Design Review Panel 01  
Advice Summary

ALEXANDRIA PARK COMMUNITY SCHOOL  
DESIGN REVIEW 01 – 28 SEPT '17,  
320 Pitt St, Sydney (Department of Planning and Environment)

**Design Review Panel 01  
Advice Summary**

ALEXANDRIA PARK COMMUNITY SCHOOL  
DESIGN REVIEW 01 – 13 OCTOBER, 2017,  
320 Pitt St, Sydney (Department of Planning and Environment)

LANDSCAPE CONCEPT DESIGN

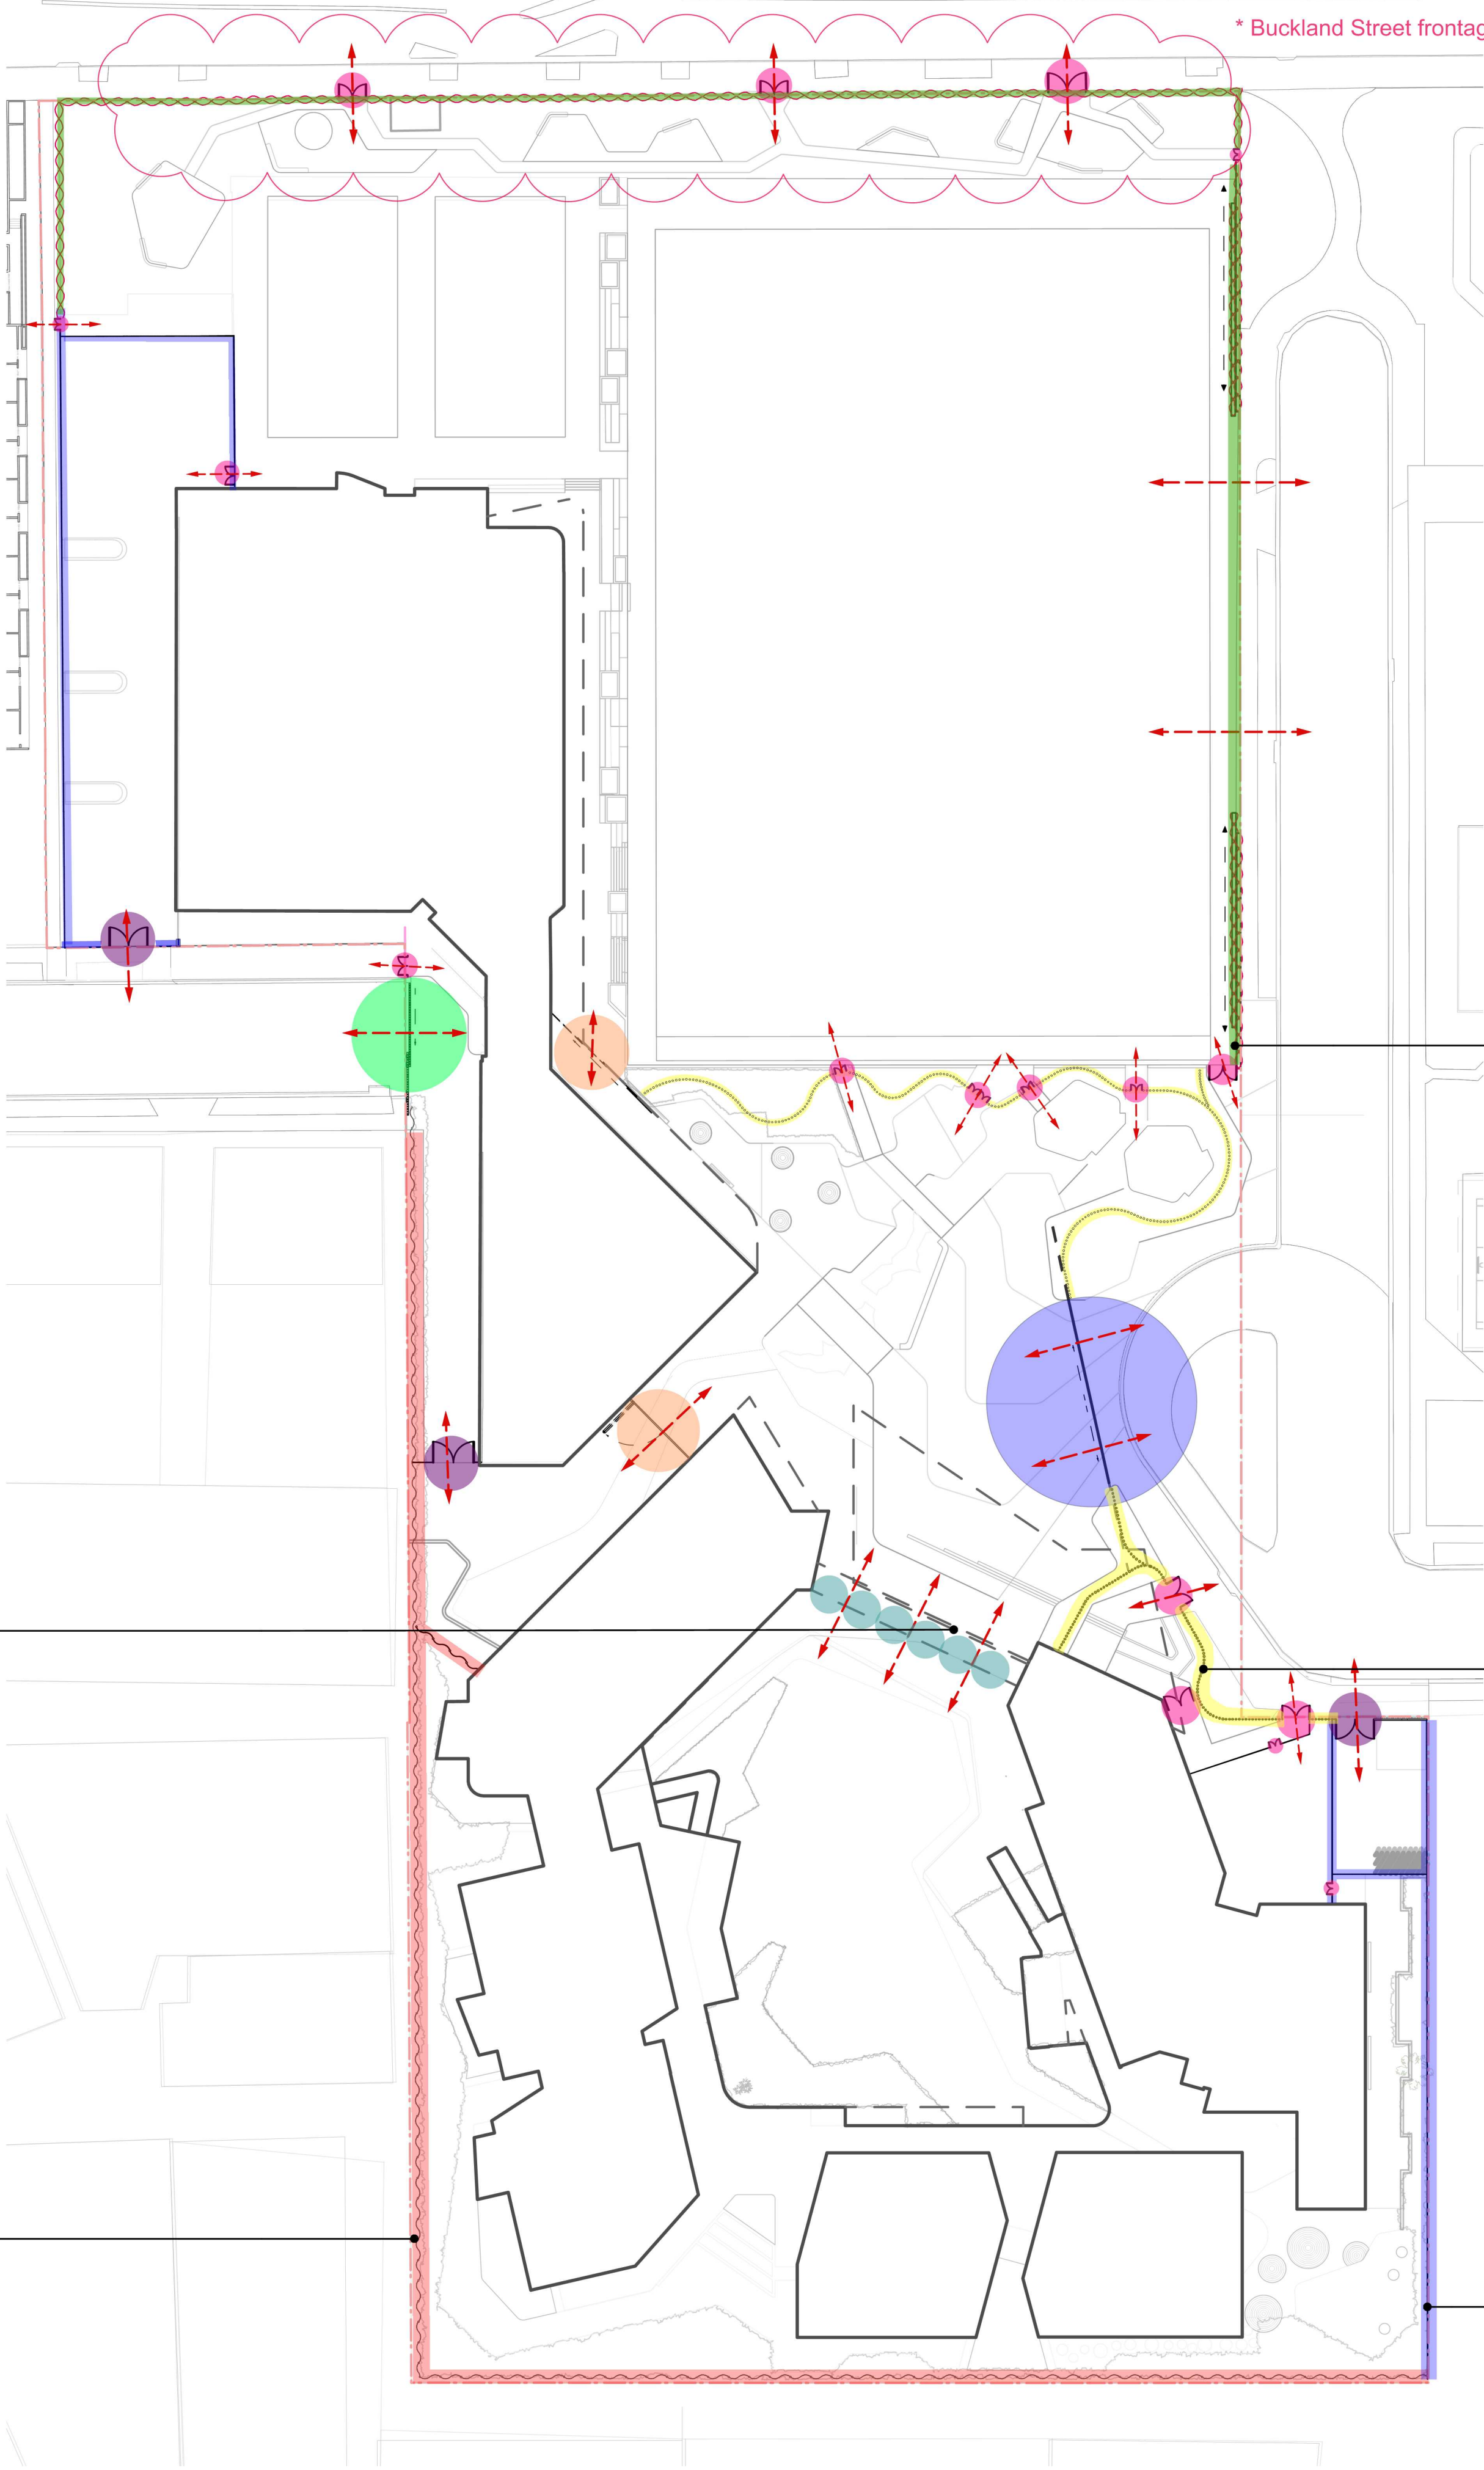
- Public art. A strategy for public art is required including commitment from DoE, program and budget.
- Landscape design. The Panel supports the landscape concept presented as a starting point. Include further detail to address integration issues noted in this letter. Visual connection from Park Road E/W across the site is supported. Increase shade to roof top areas.

- The Panel supports the landscape concept overall, noting that issues raised above will require further development of the landscape strategy (integrated fencing, rooftop open space design).

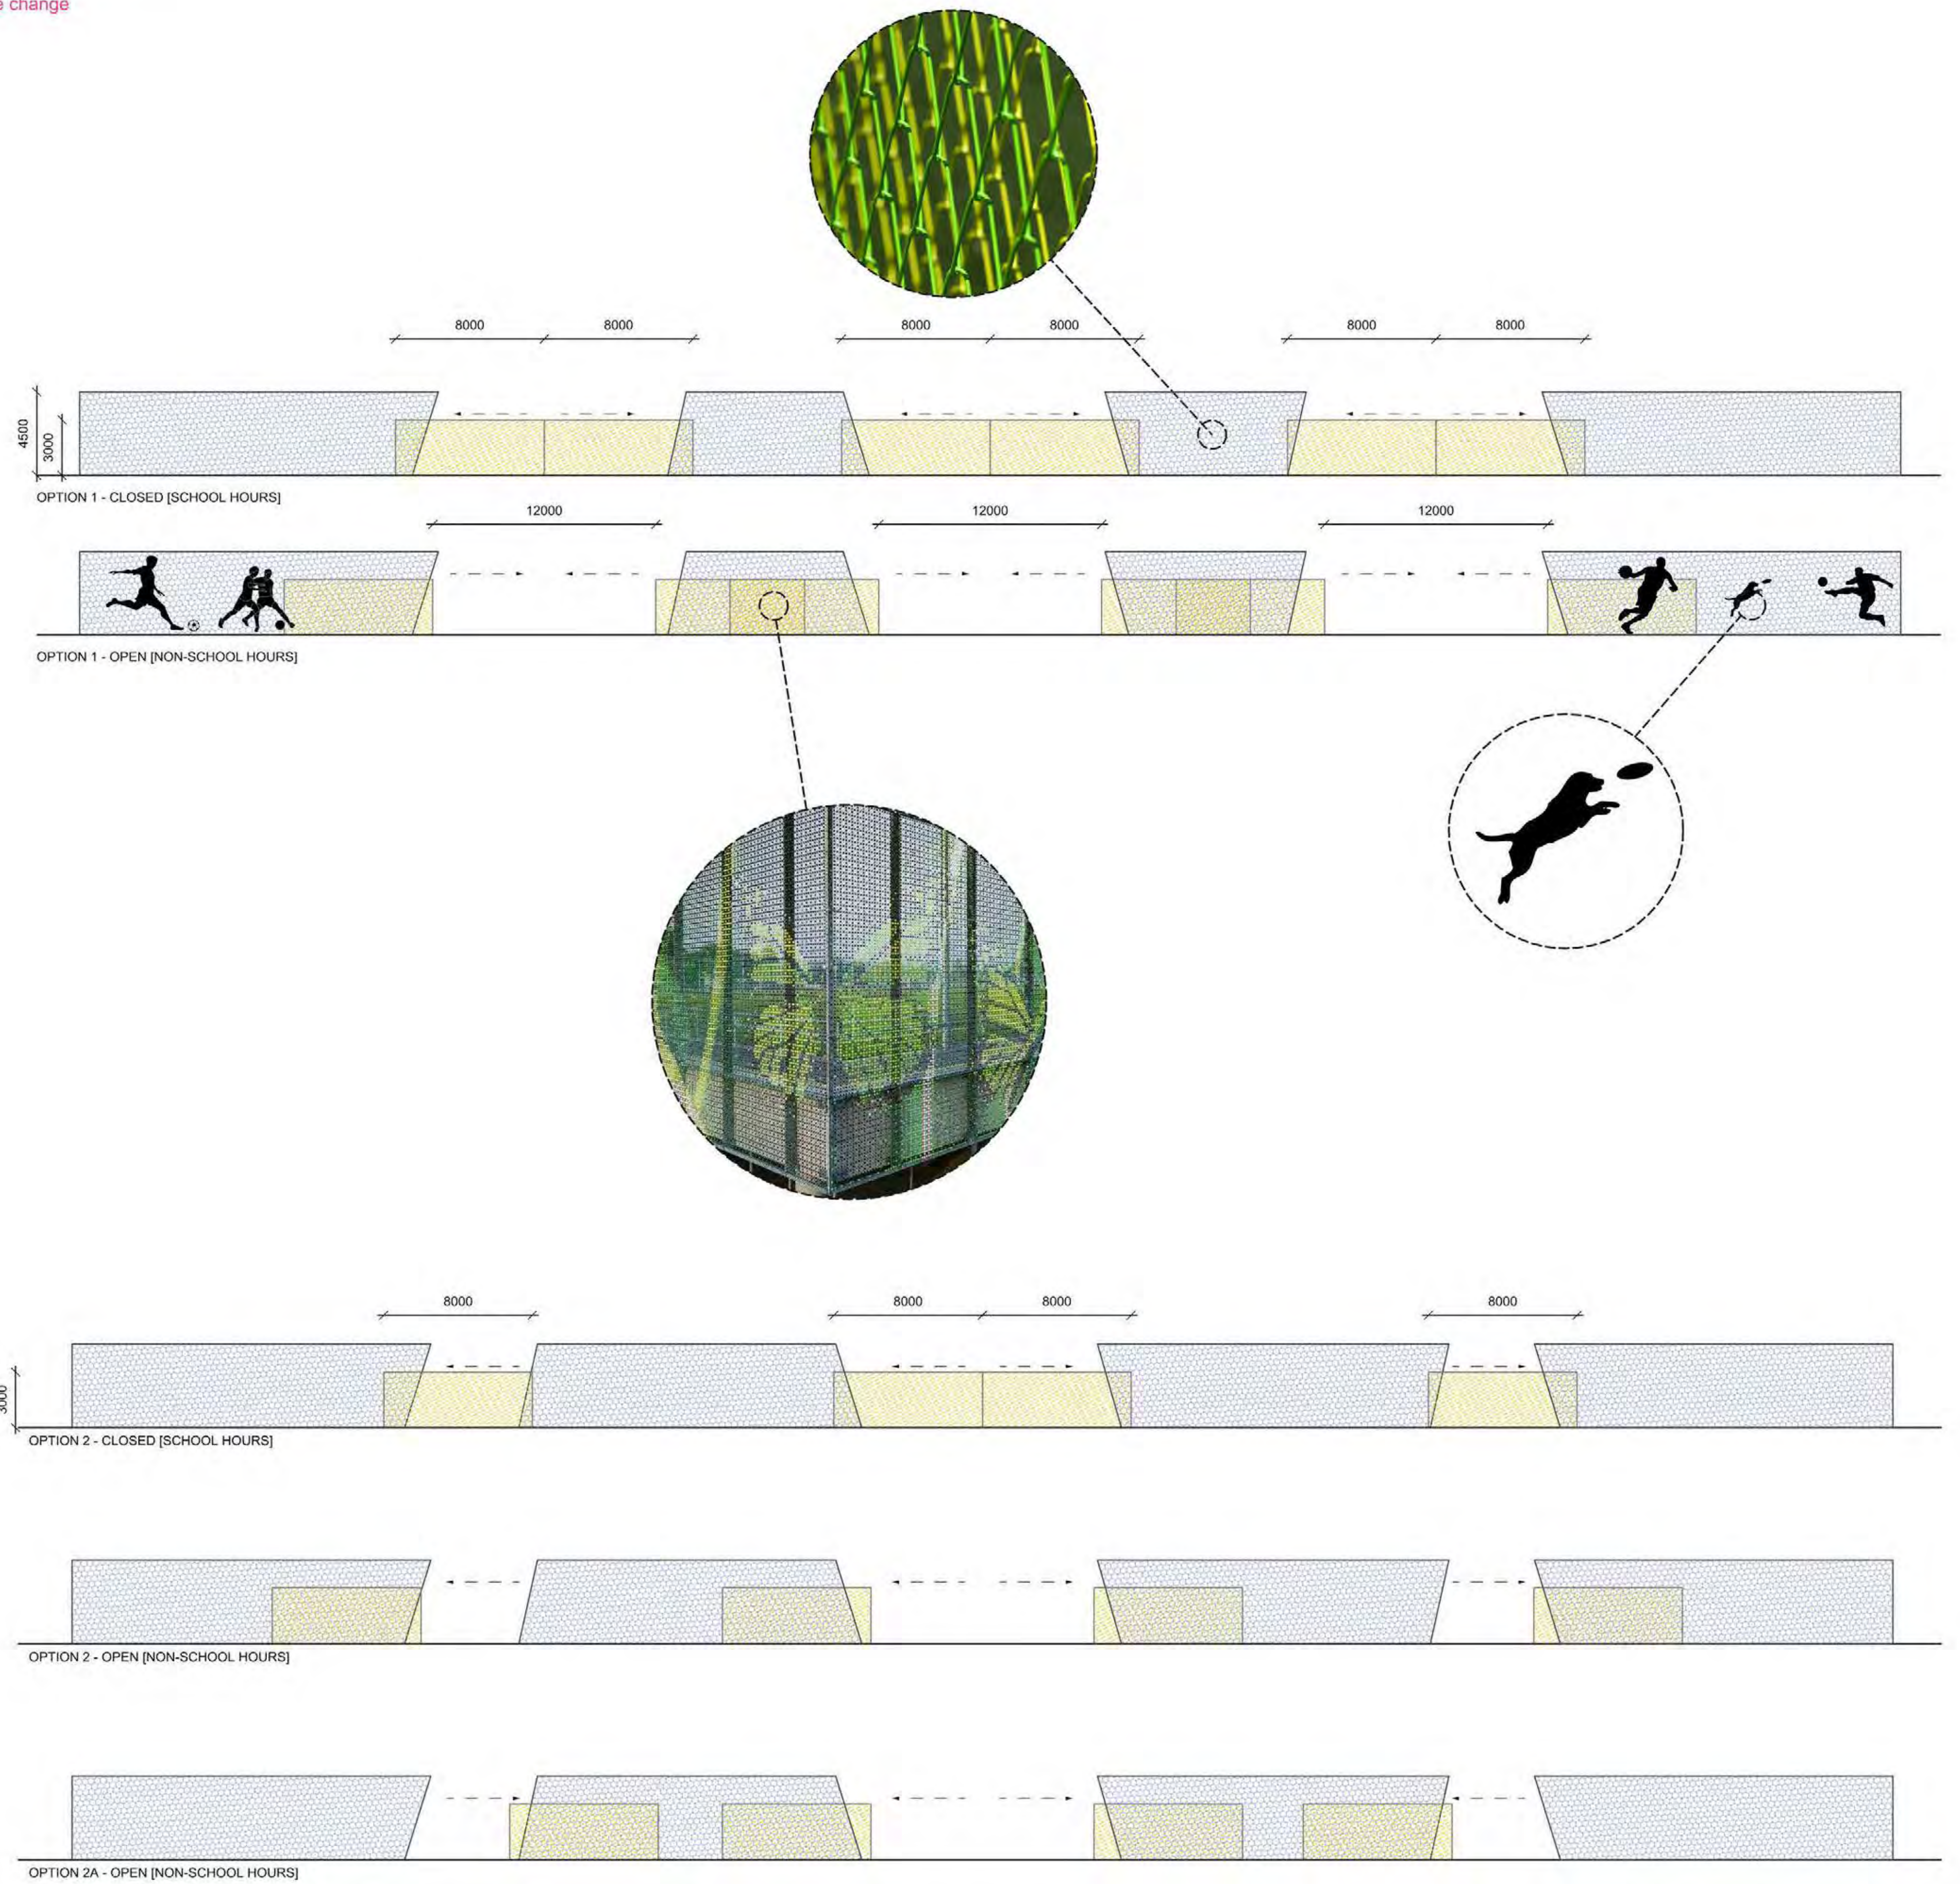
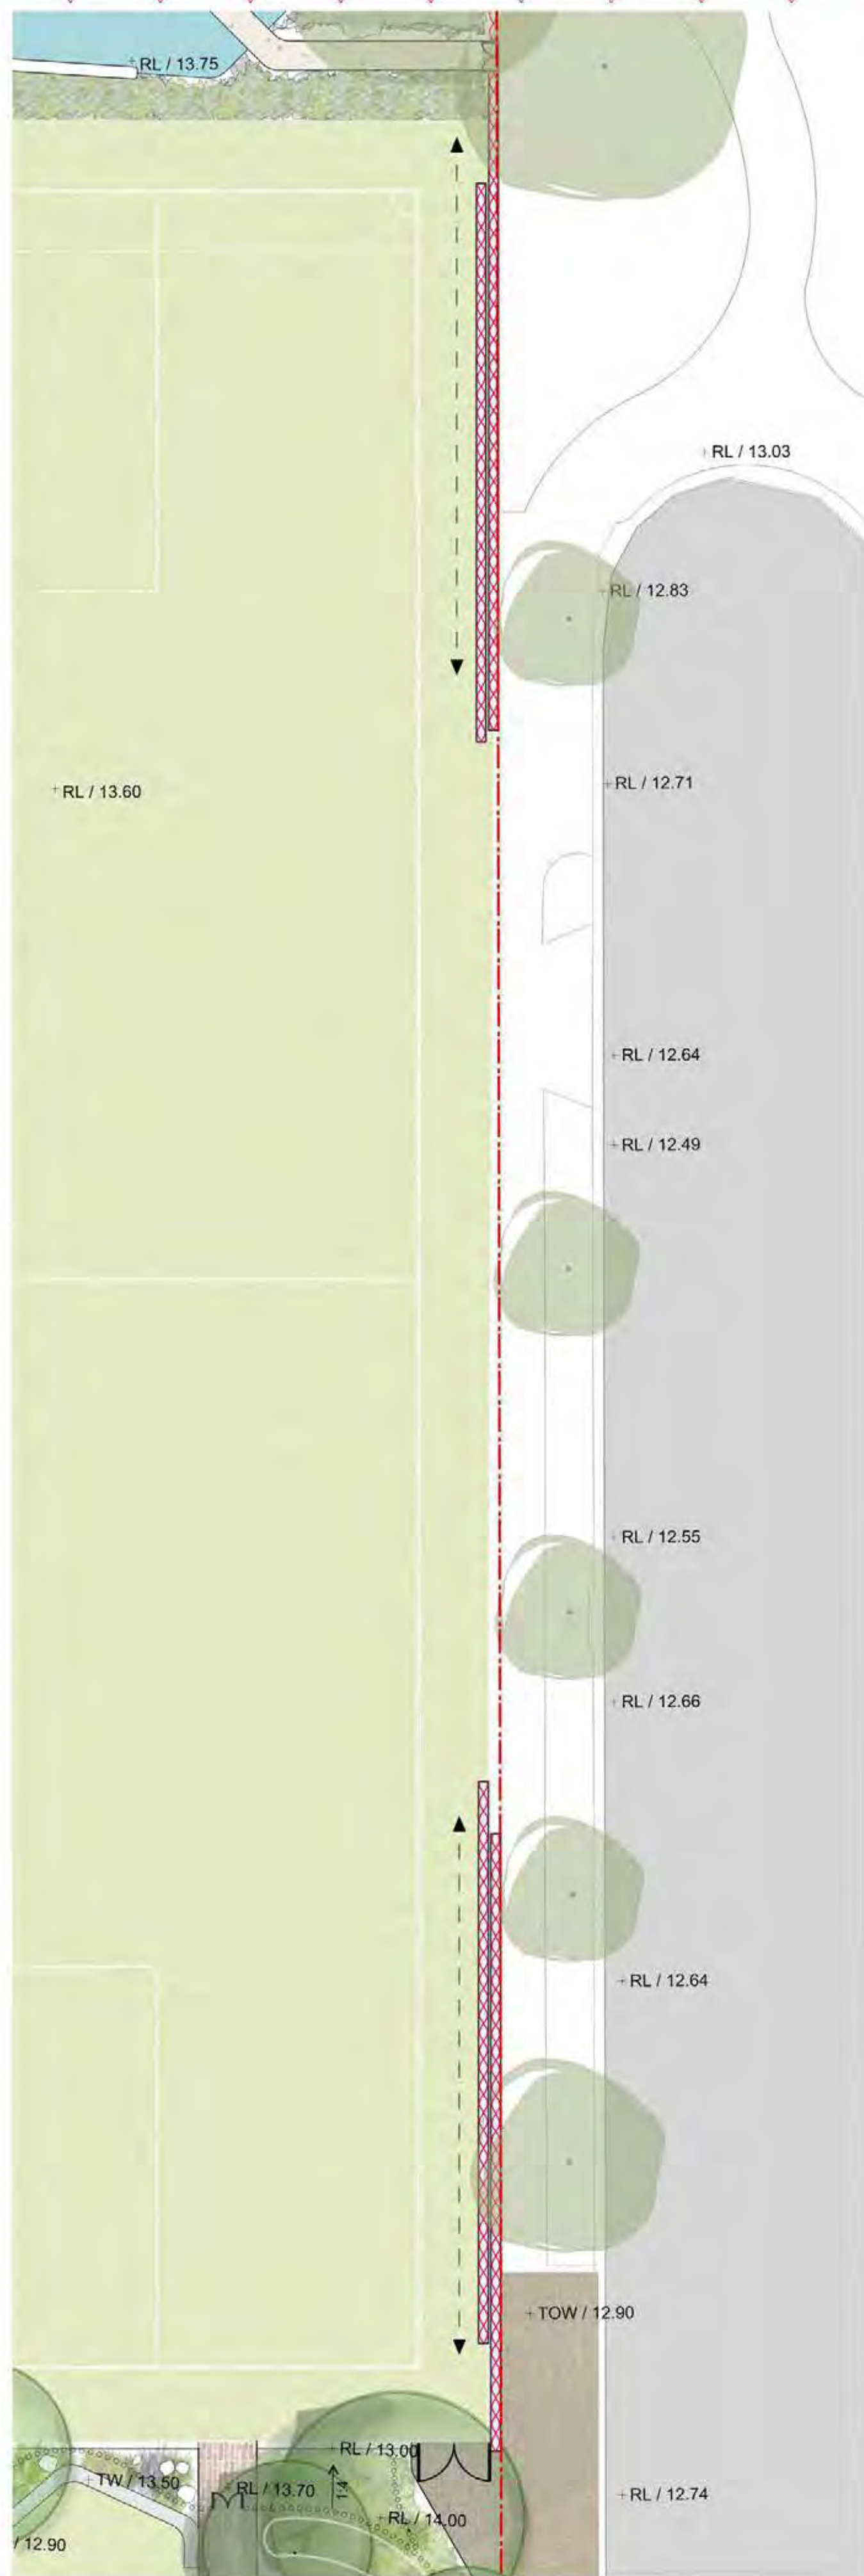
- Design of fence and gates including roof top fencing. Provide detail on the height, materiality, visual permeability, integration with landscape design, planting and streetscape, and with the coordinated site wide response to circulation, wayfinding and after-hours access. To include typical details of new fences and gates and modifications to existing (where proposed).

- The Panel acknowledges provision of further detail as requested. However, a coordinated site wide response to circulation, wayfinding and after-hours access is still unclear.
- The Panel note that façade screen, roof-top fencing and perimeter fencing should read as integrated and coherent design elements.

- Roof top shade elements: further detail is required to demonstrate visual impact and coordination with other elements. Confirm the extent of shading required for early child care centre.
- The Panel strongly recommends the approach to screen and fencing should be resolved, and this approach be endorsed by DoE according to their security requirements, prior to lodgment
